Your Ref: OWPC18999
Our Ref: AW/132/18/HH
Please ask for:
Pat Aird

29th June 2018

Single storey front extension & bow window to front.
4 The Lawn Aldwick

Drawing:
DESIGN PROPOSALS

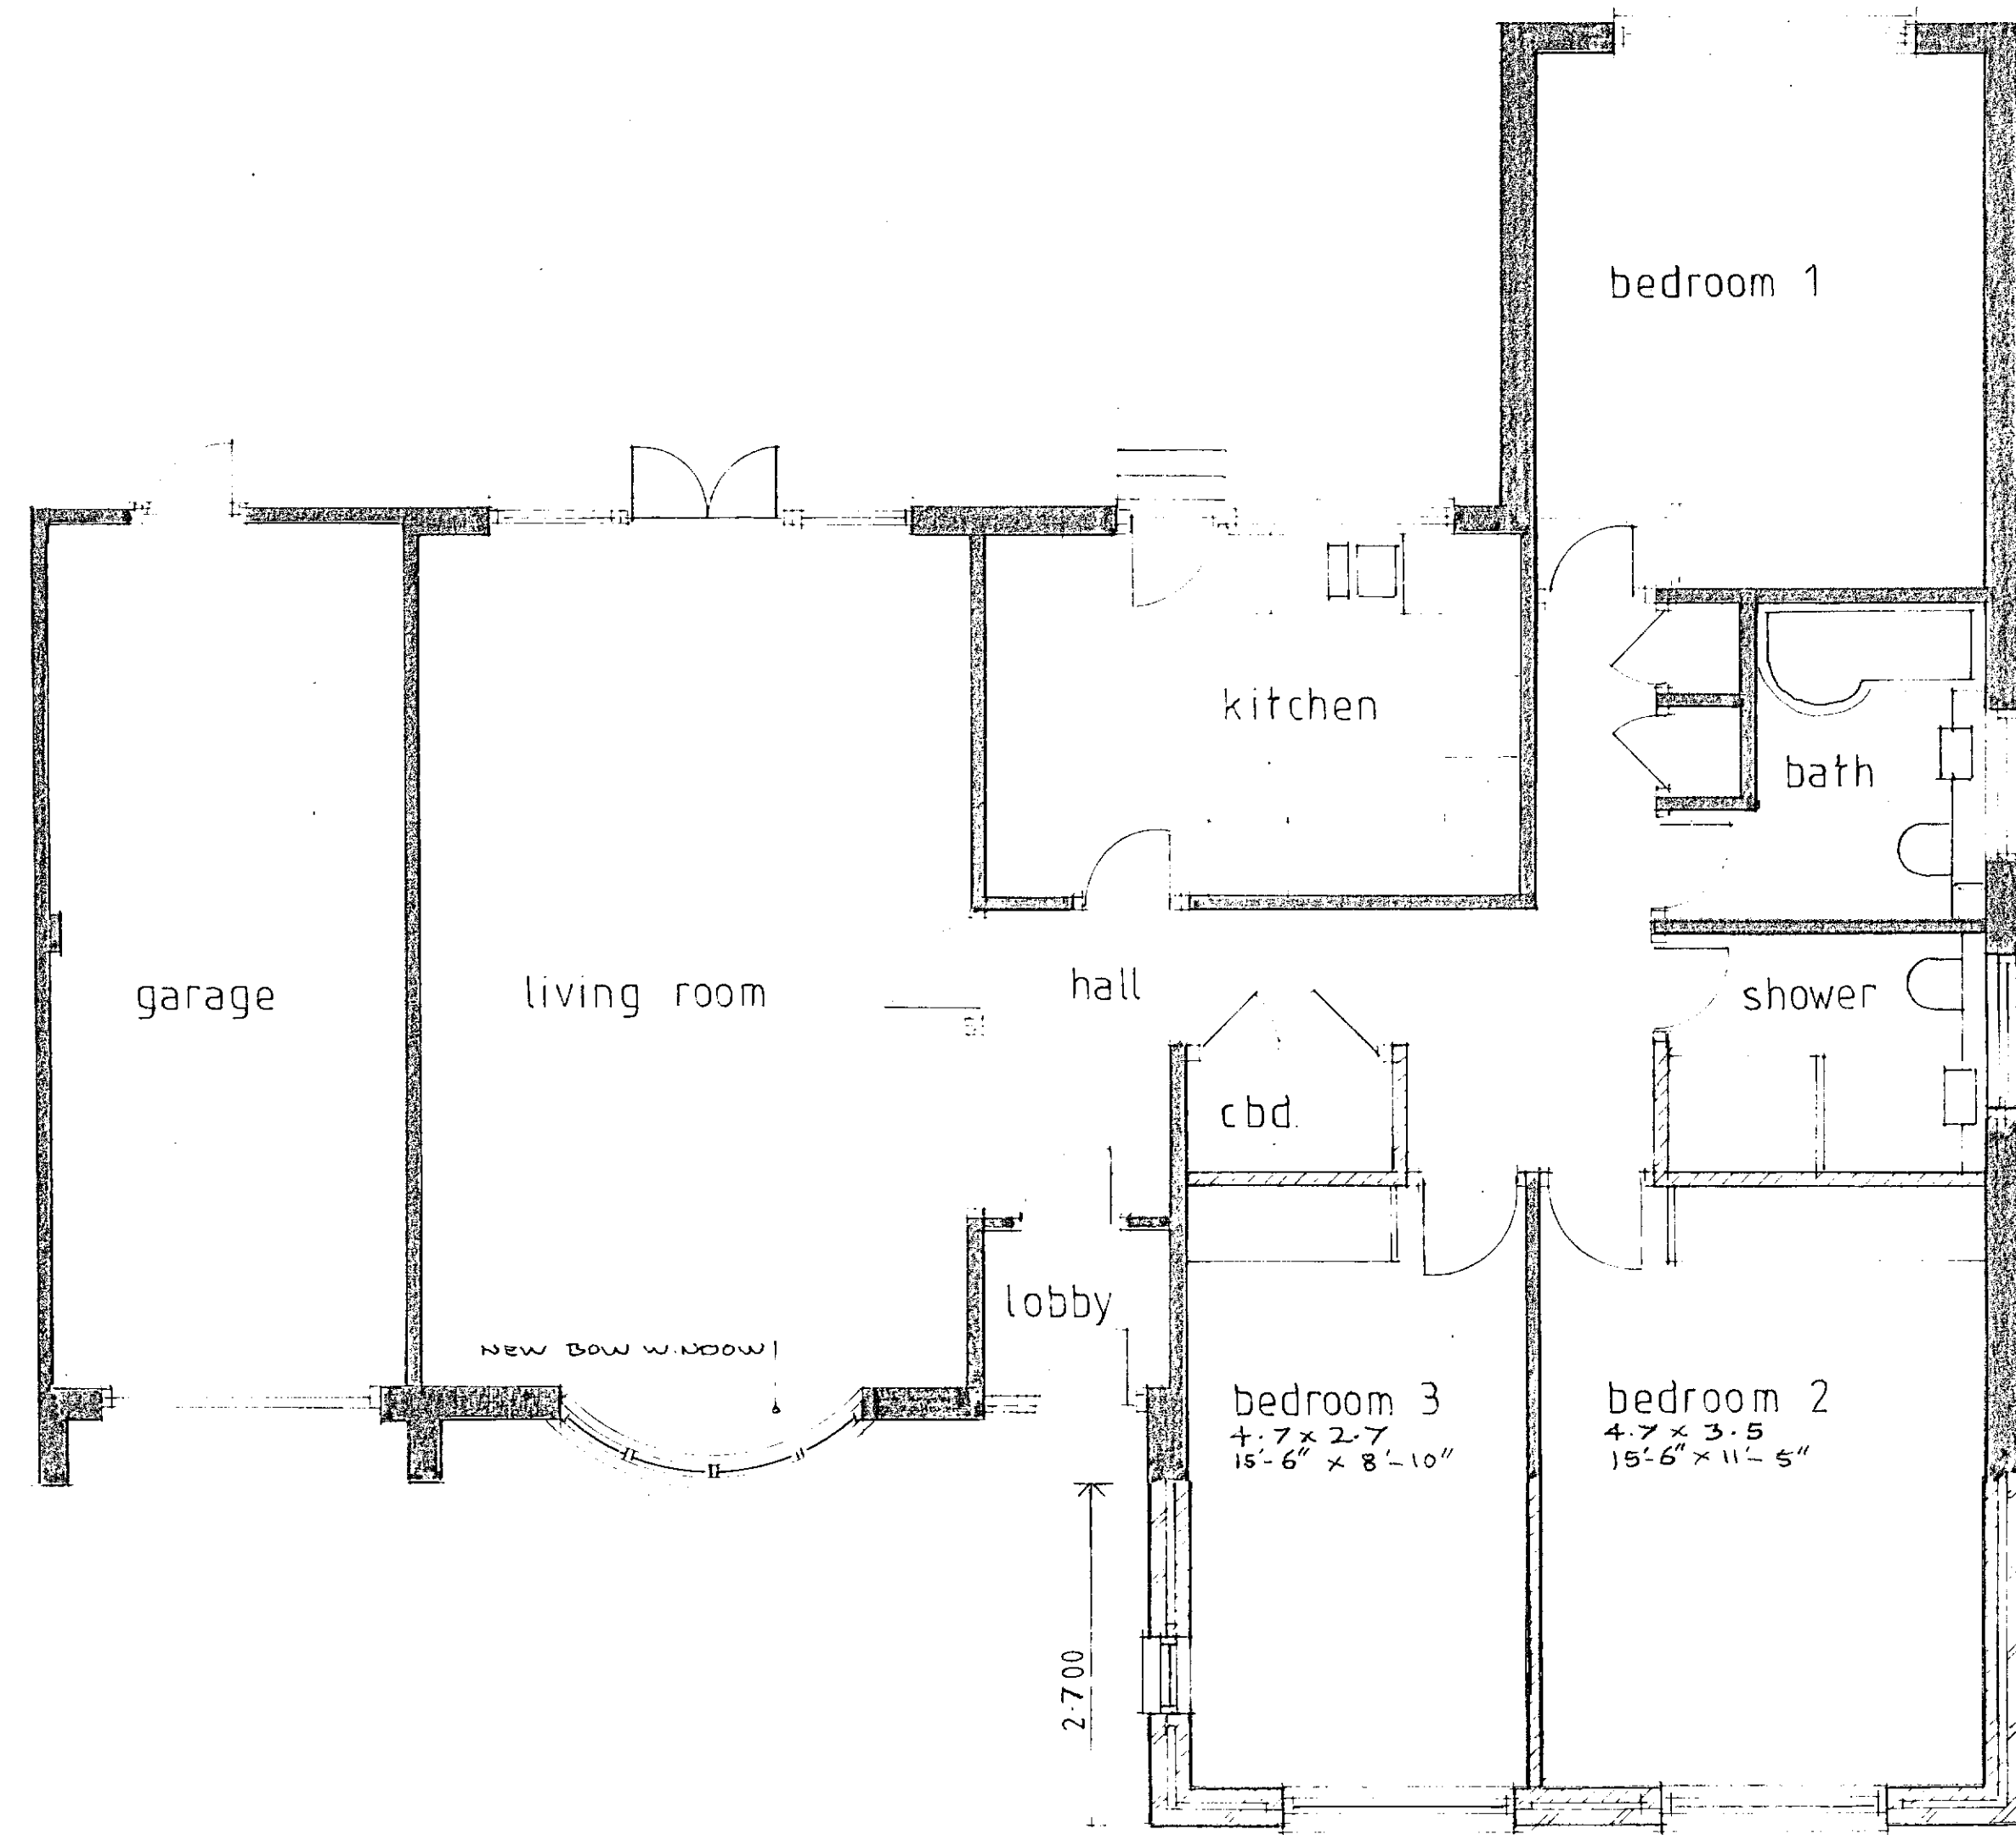
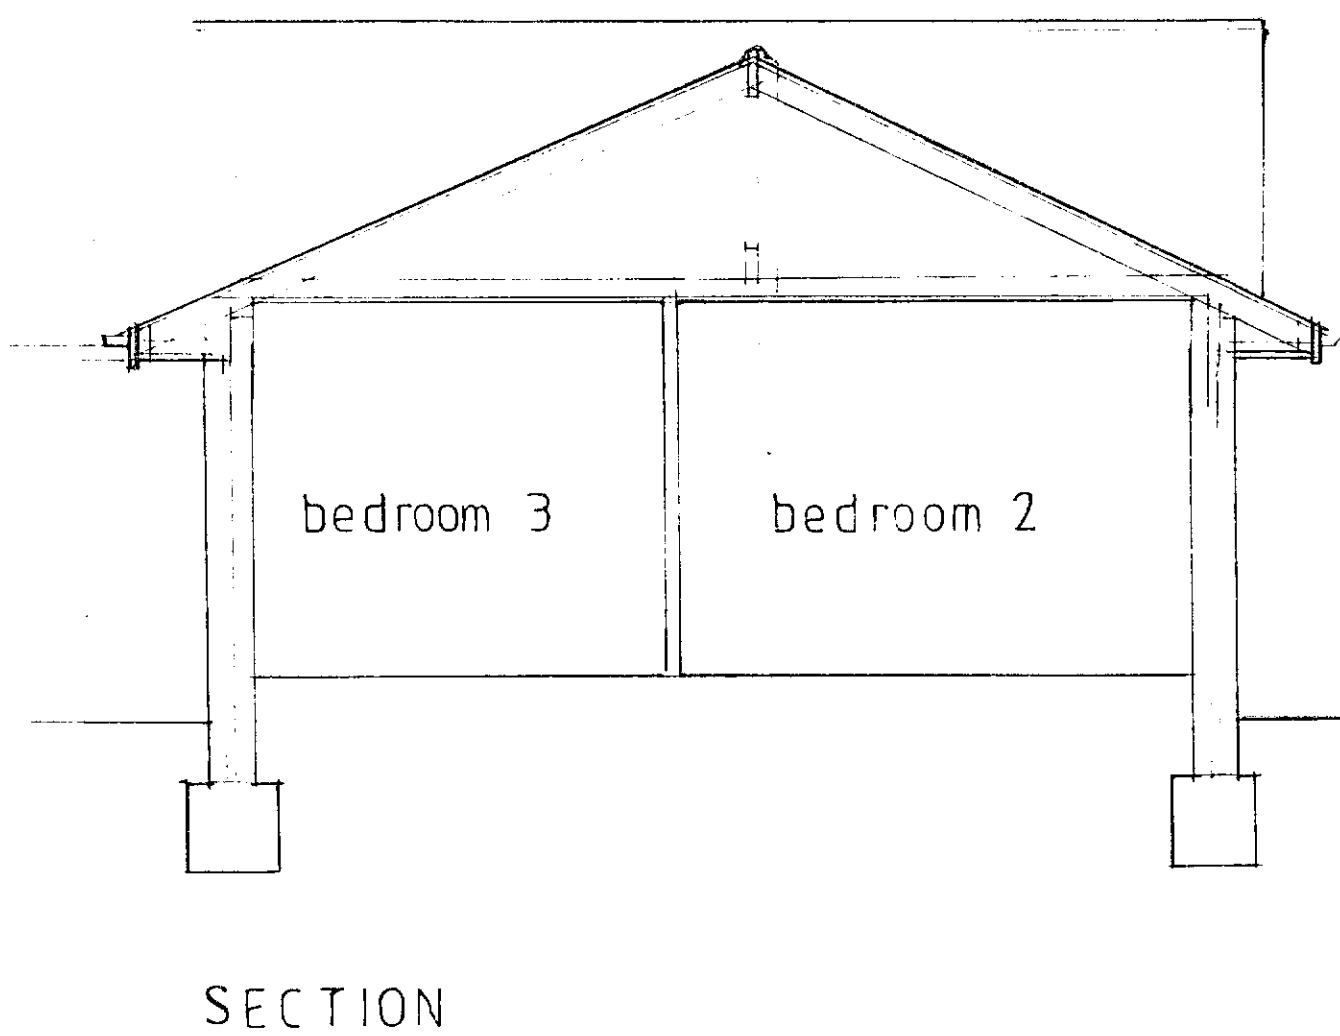
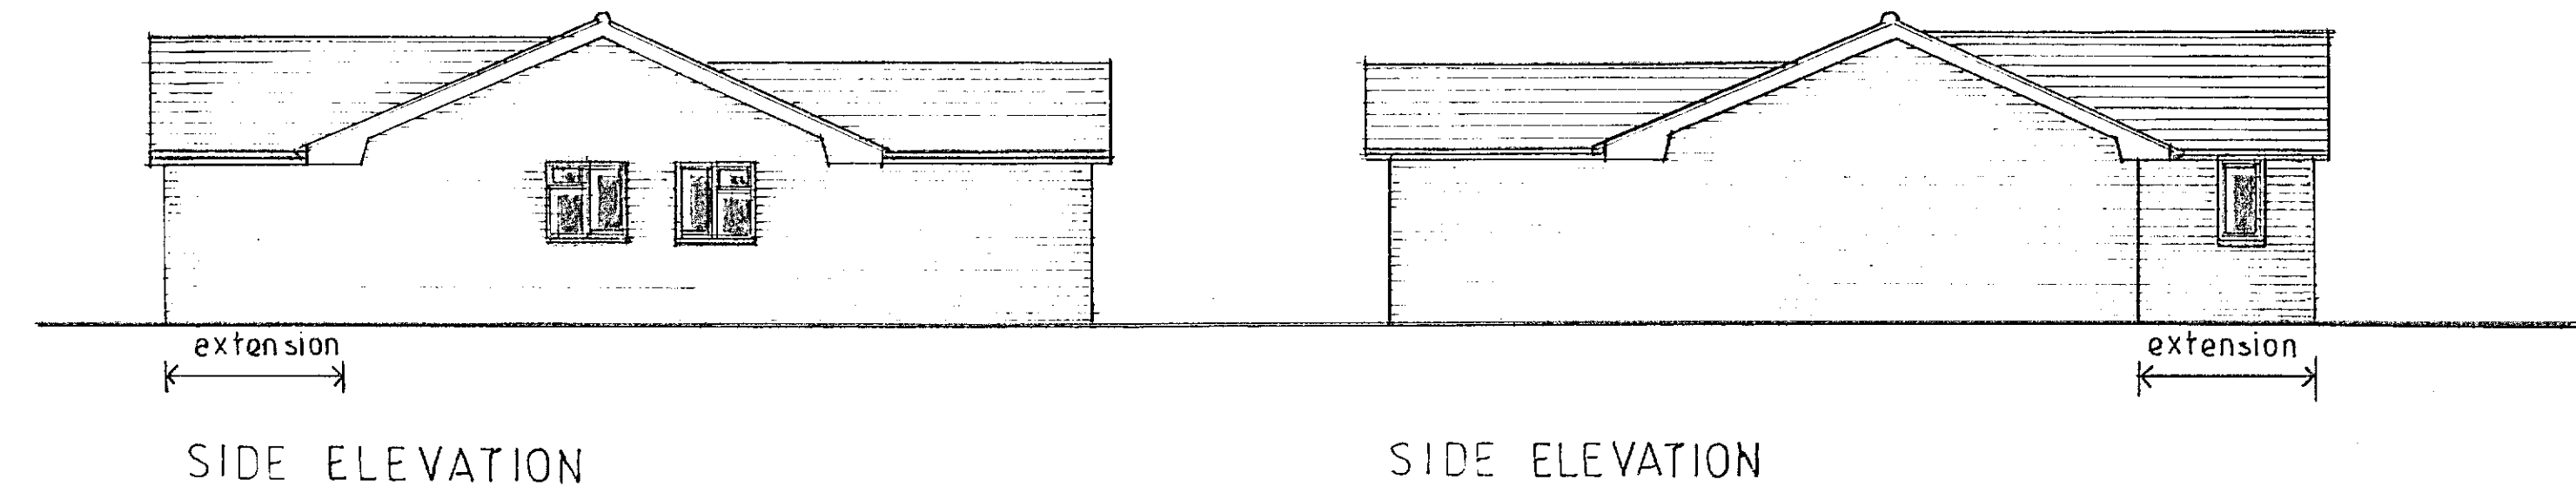
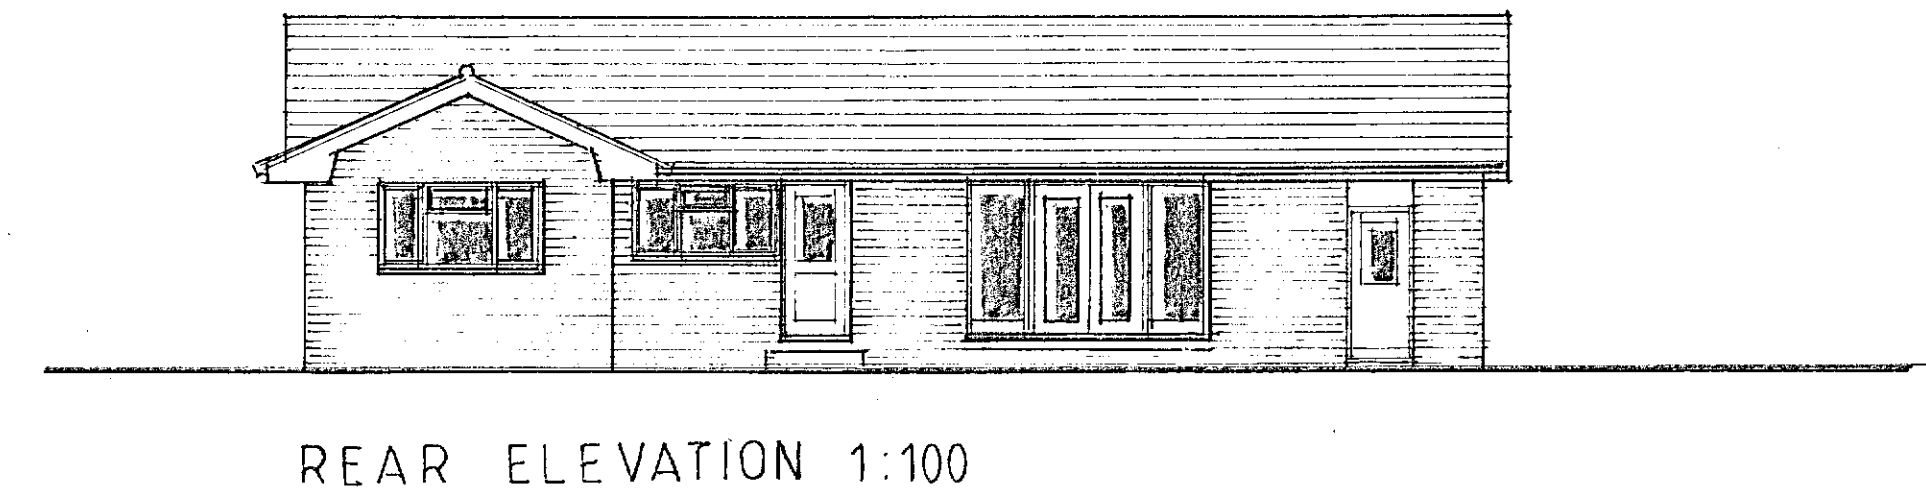
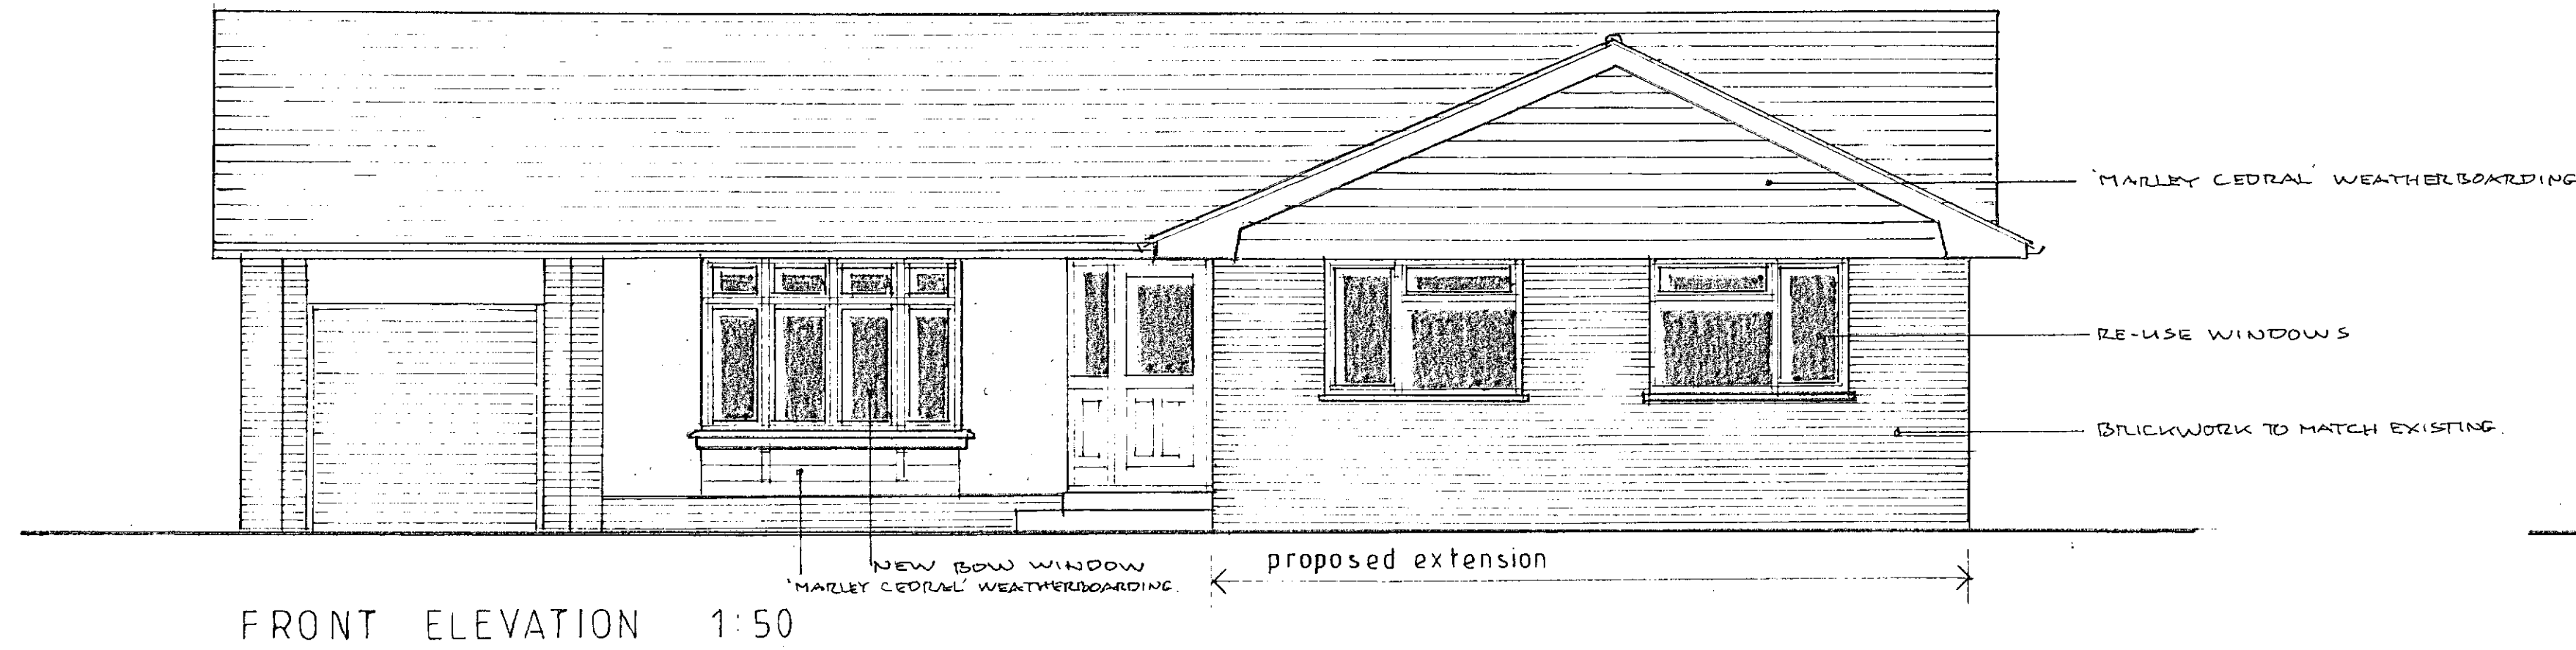
*Members had no objection to the above application however,
They expressed concerns that the extension may affect the amount of light to the kitchen
of the neighbouring property which was difficult to assess as no measurements were
supplied.*
